Ribble Valley Borough Council
By email

Your ref: 3/2023/0812
Our ref: DC/23/3762
Date: 27-NOV-23

Location: Old Row Whalley Road Barrow BB7 9AZ

Proposal: Approval of details reserved by conditions 5 (surface water drainage),

Drainage Layout

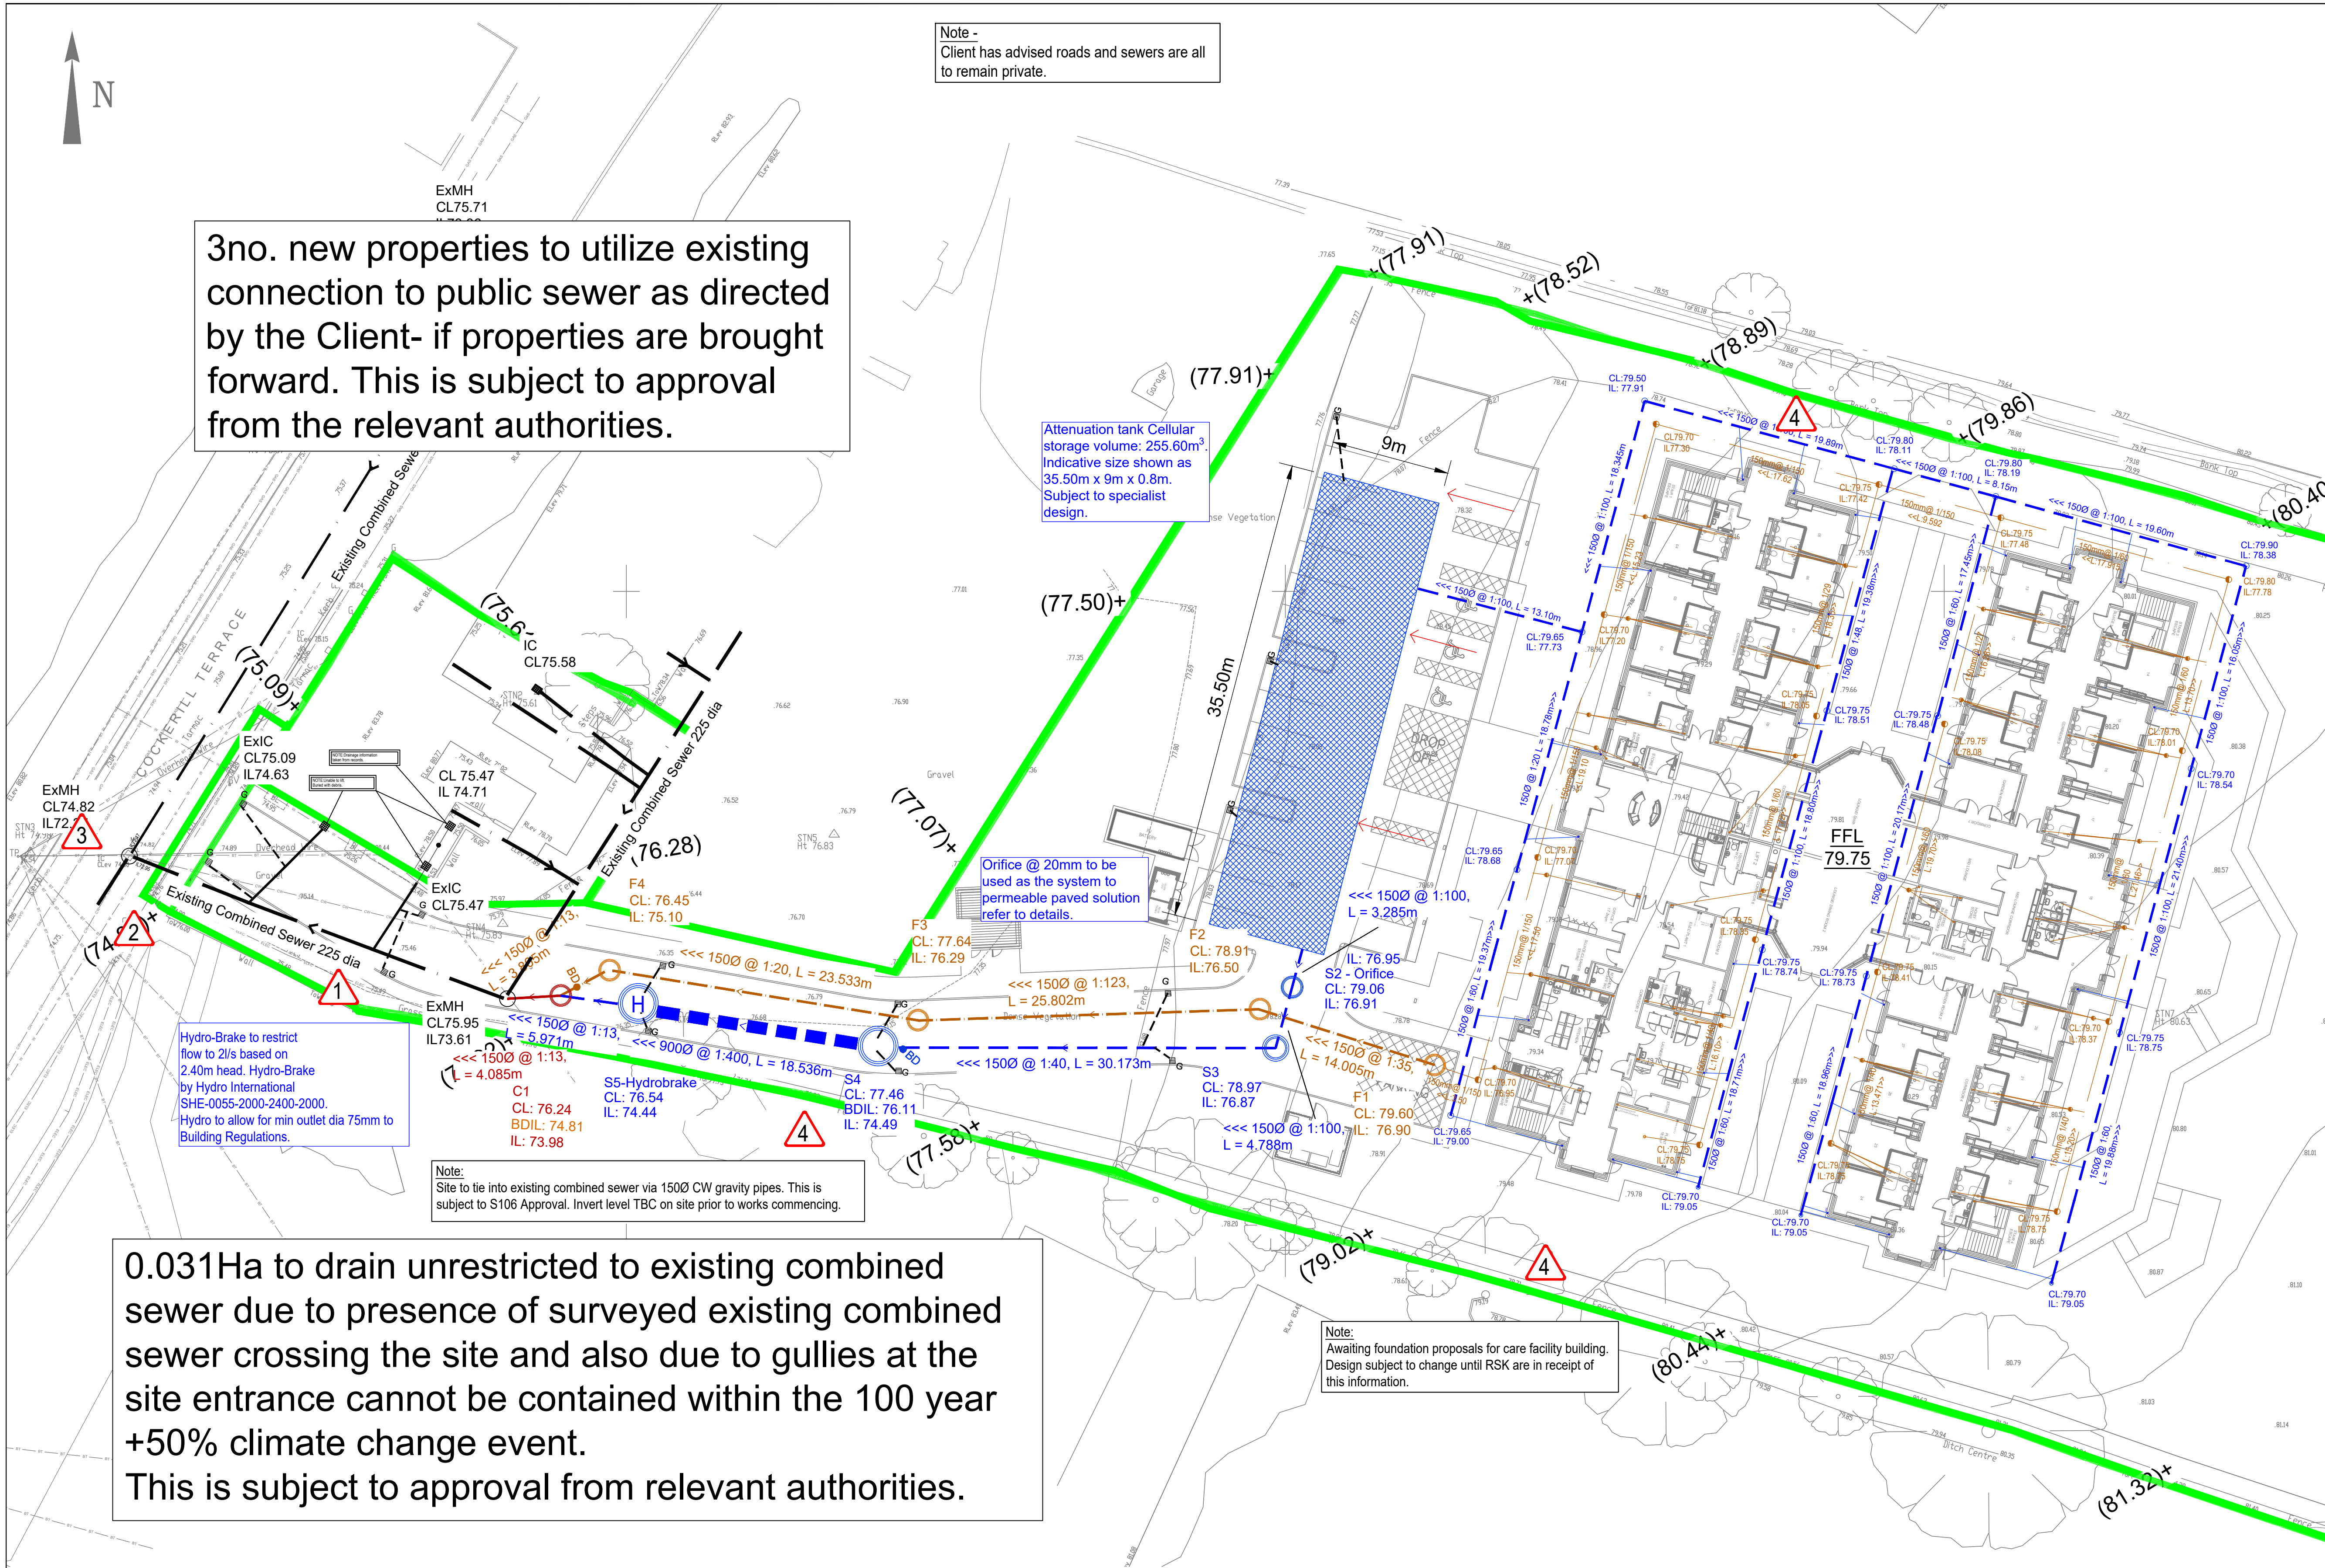
- a) Hydraulic calculations
- b) Associated drawings
- c) Evidenced in hydraulic calculations which have not been provided.
- d) The latest pre-development enquiry UU Ref - 03037995 does not allow surface water into the combined sewer network.
